Department of Transportation

August 31, 2022

RE: Guntzelman Porcelain Pines Subdivision
SP 225 | Preliminary Plan for 6 Residential Lots

SHEET # **FIG. 2**

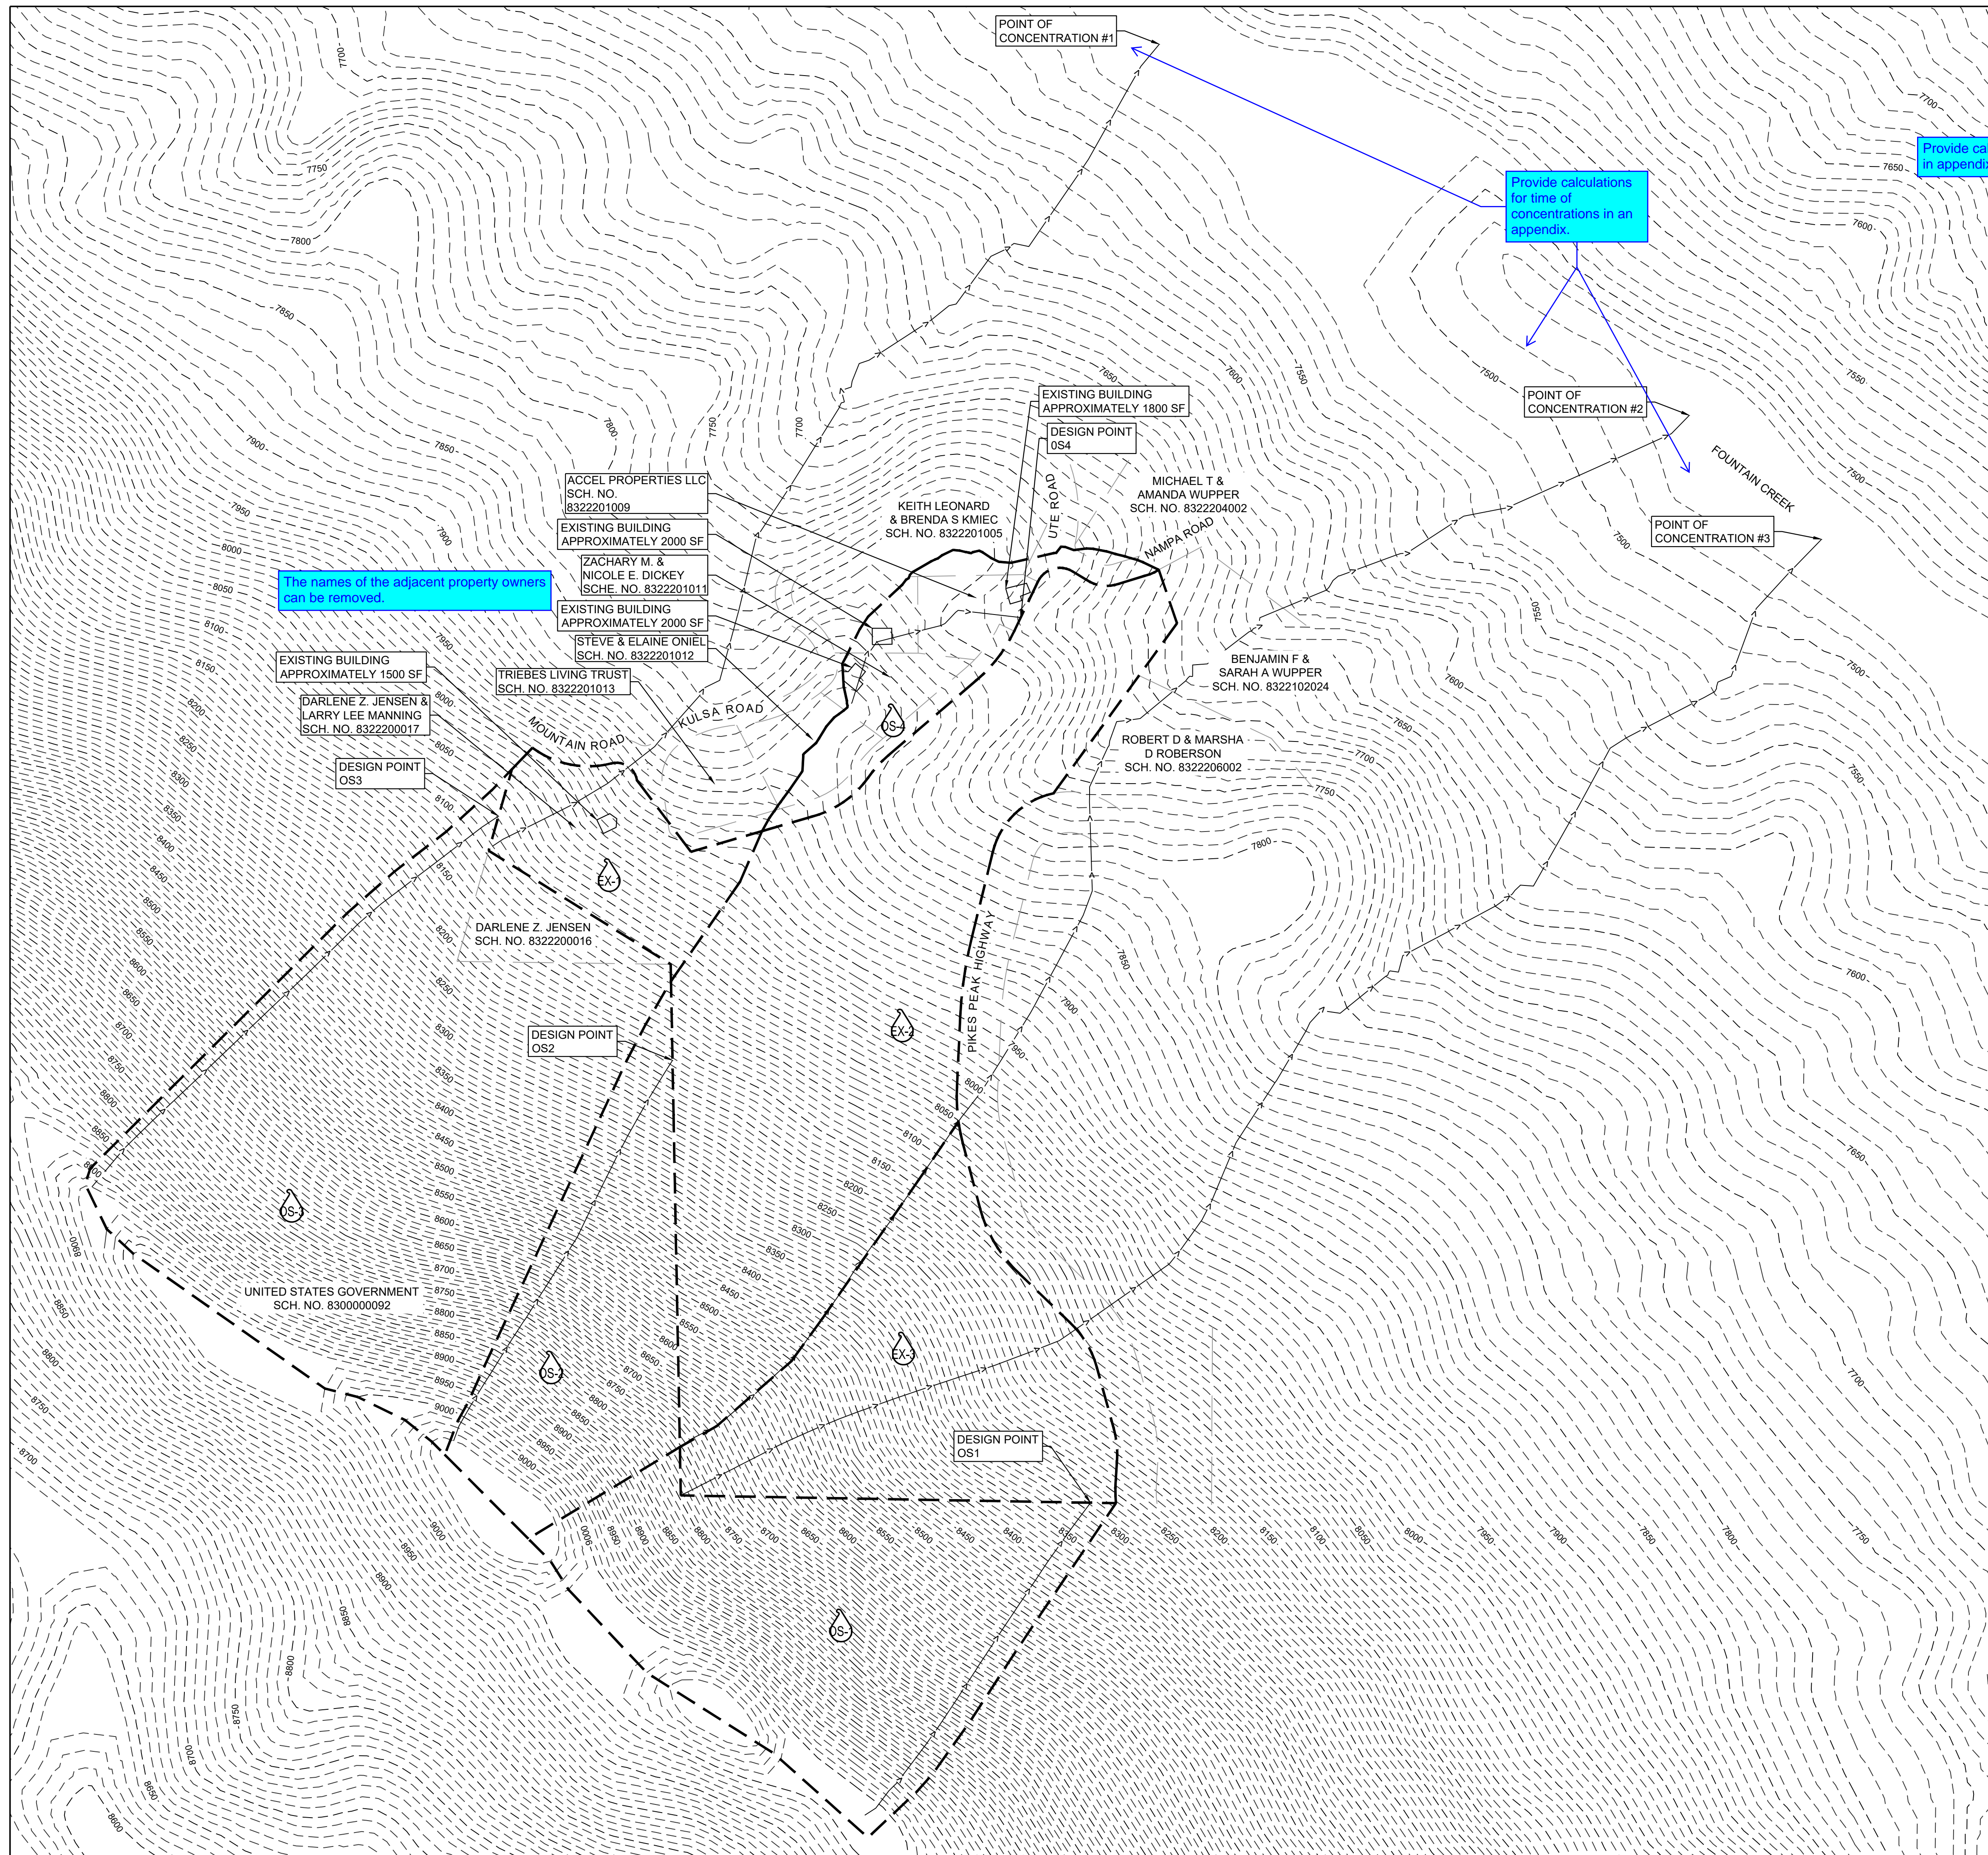
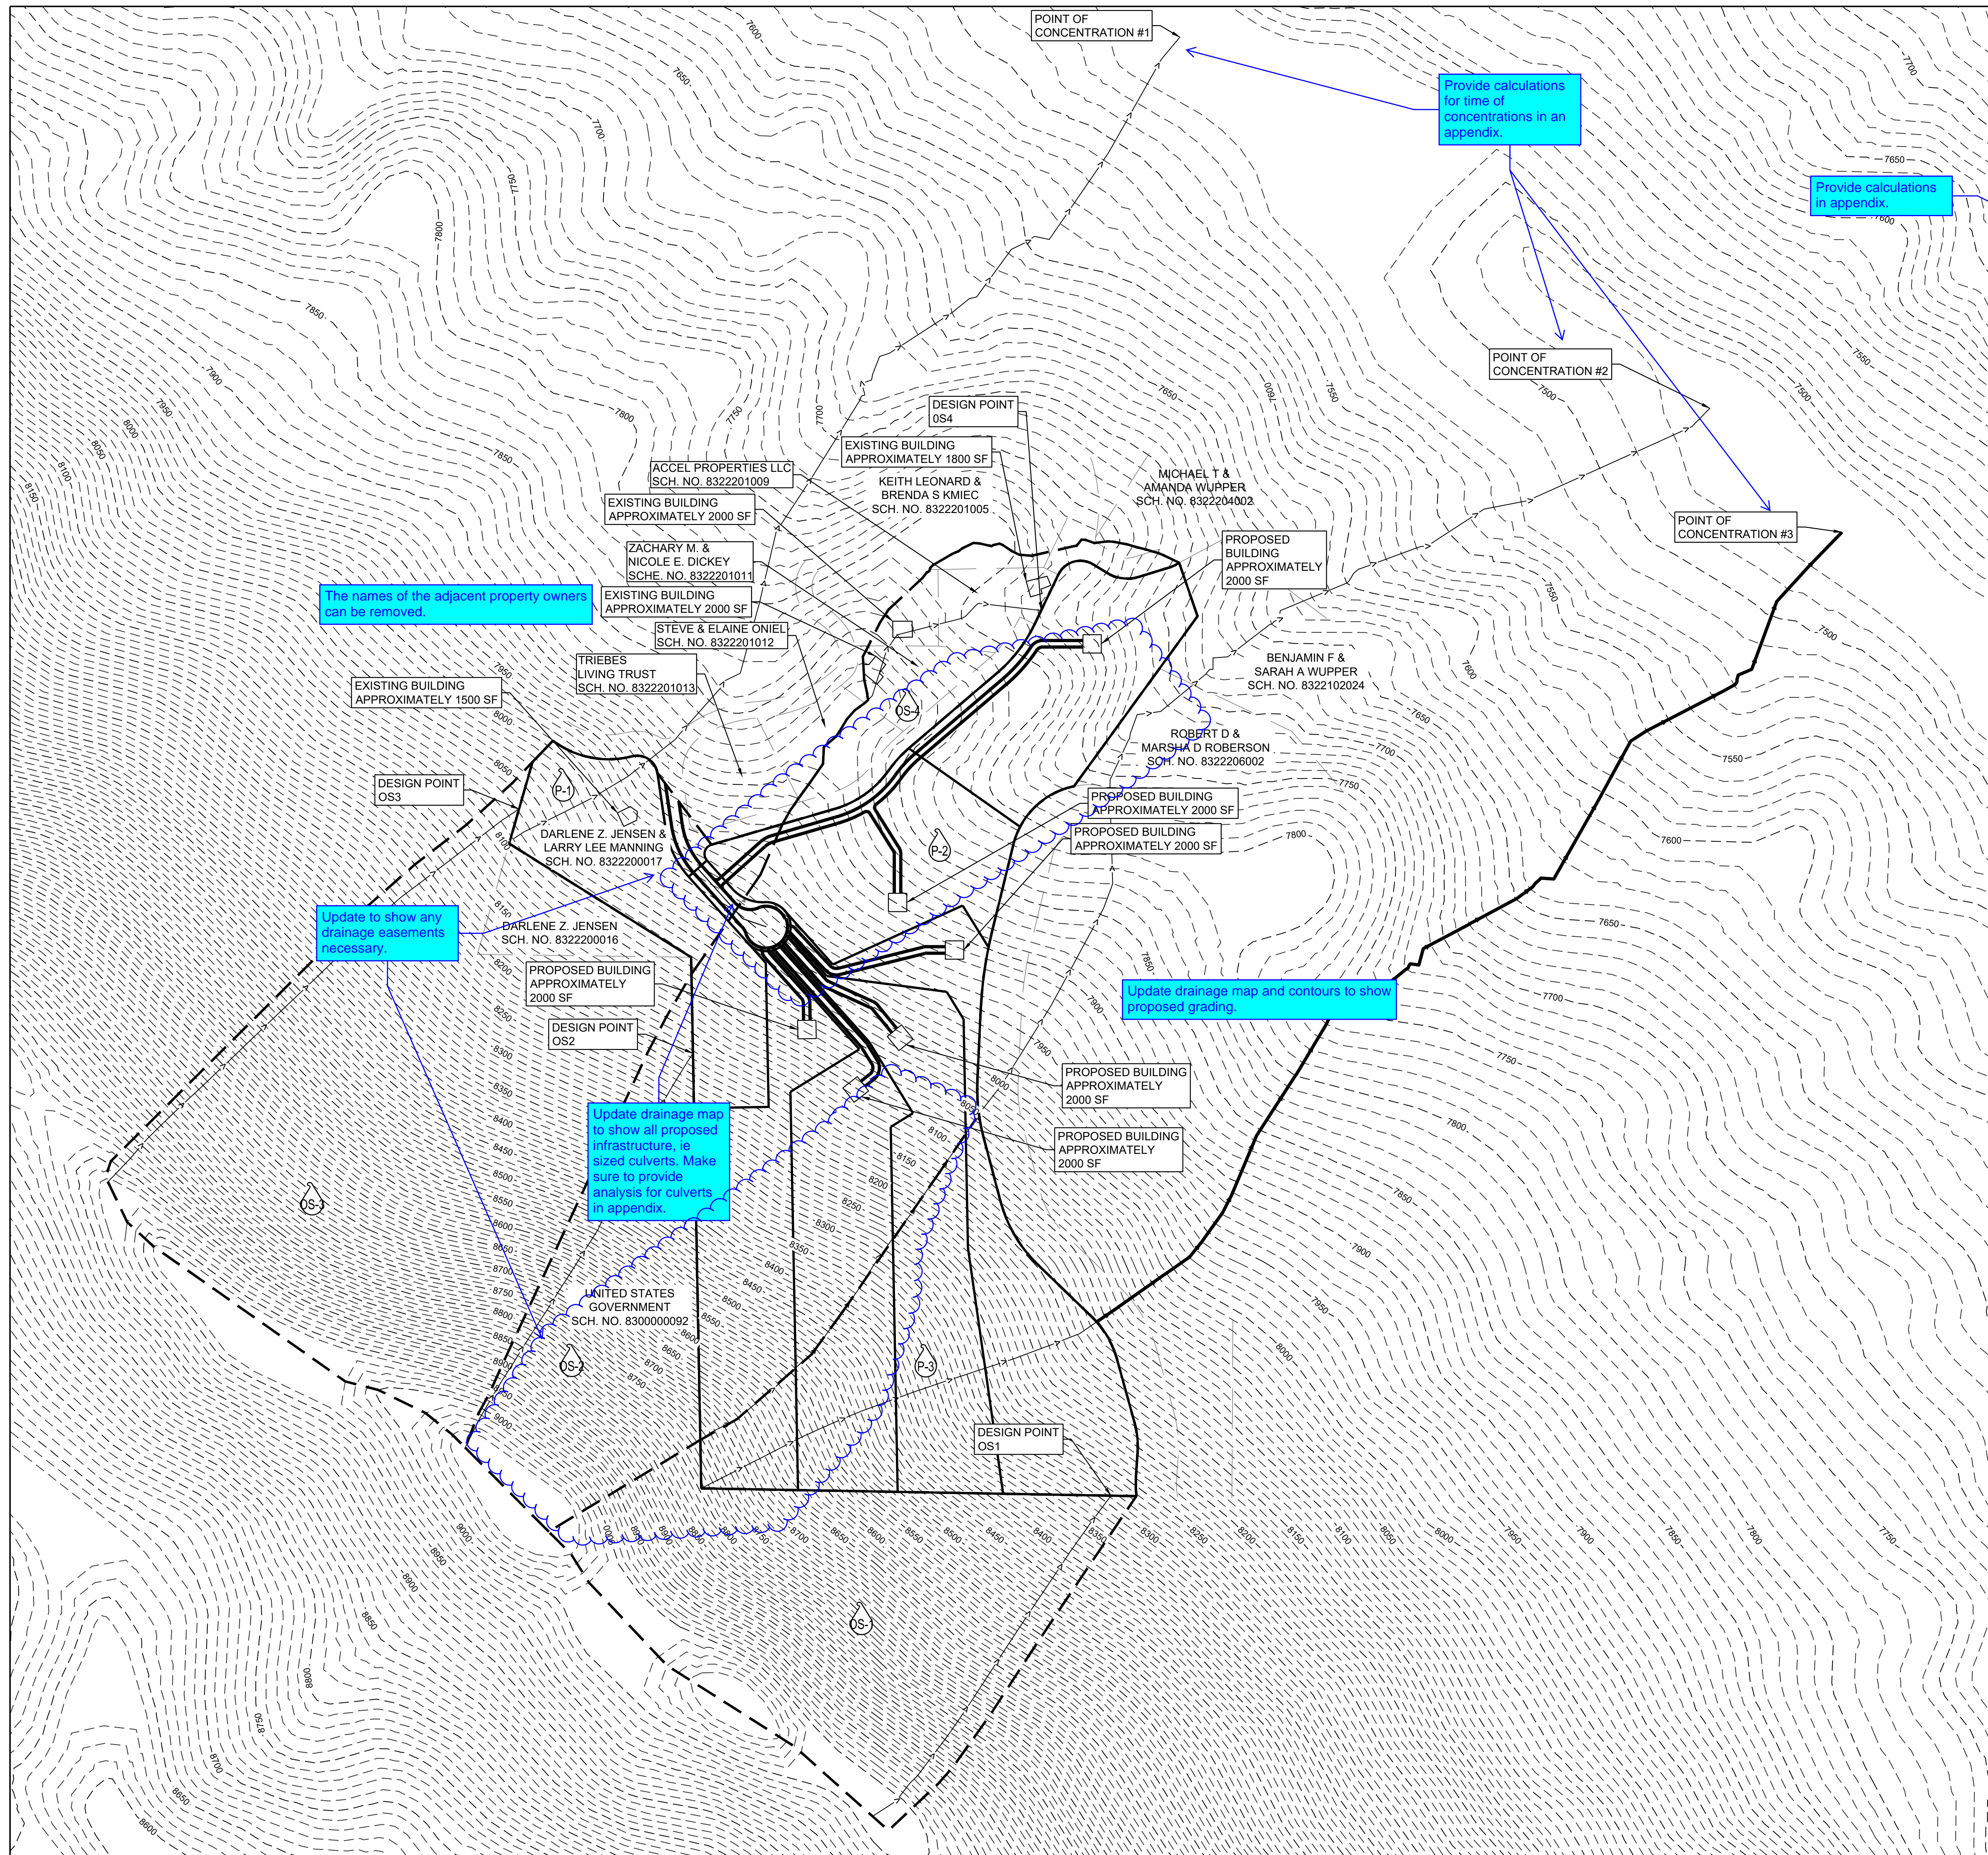
- Revise time of concentration lines and values for basins 1, 2, and 3 for both pre-development and post-development conditions.
 - Time of concentration lines should be drawn to the drainage basin outlet. Additionally, the proposed ditches will change the contours and will change the time of concentration lines and values for the impacted basins.
 - Update pre- and post-development peak flowrates accordingly.
- Verify that the proposed subdivision will not result in increased runoff to Fountain Creek and make design changes as necessary to minimize those impacts.
- Provide plans for the proposed roadside ditches and show proposed contours on the post-development drainage map.
